Our ref: AE/2025/130509/03-L01
Your ref: EN010109

Date: 15 July 2025

APPLICATION BY NORTH FALLS OFFSHORE WIND FARM LTD FOR NORTH FALLS OFFSHORE WIND FARM

THE EXAMINING AUTHORITY'S WRITTEN QUESTIONS AND REQUESTS FOR INFORMATION (EXQ3)

**Figure 1 Hungersdown Farm Groundwater Levels**

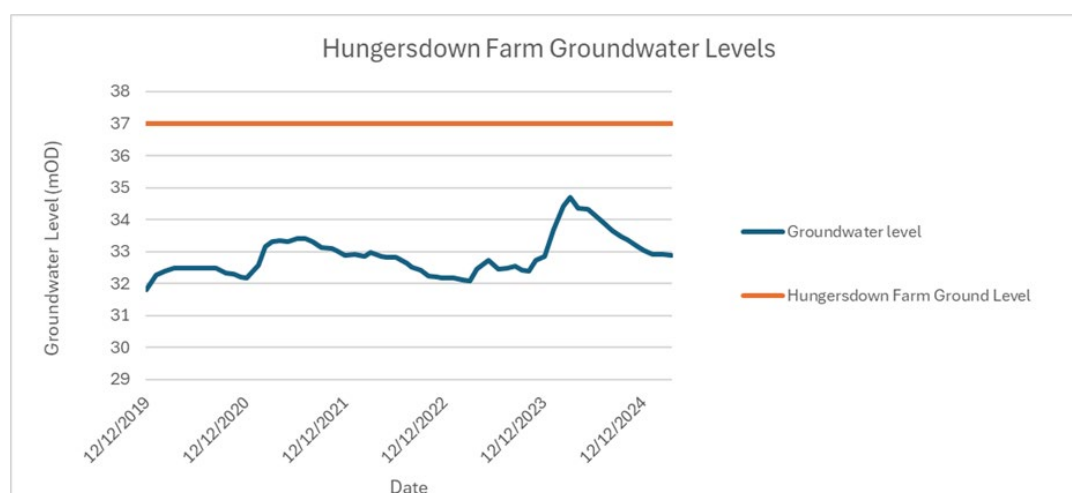
(112.) The statement here that levels collected in July/August 2024 are similar to levels following dry summer periods is not correct. Groundwater levels, specifically at Hungerdowns Farm were exceptionally high from March to October 2024, with record highs for respective months occurring from March to June of that year. I would strongly suggest a more complete review of data from this monitoring point (available on the Hydrology Data Explorer) to attempt to extrapolate a more conservative assessment. It is unfortunate that the applicant was only able to collect data from private water supplied in 2024 to submit at this time. At time of writing (July 2025) we are currently in a period of dry weather so I would suggest some comparative data could be collected this summer as levels are still in a recession from last year.
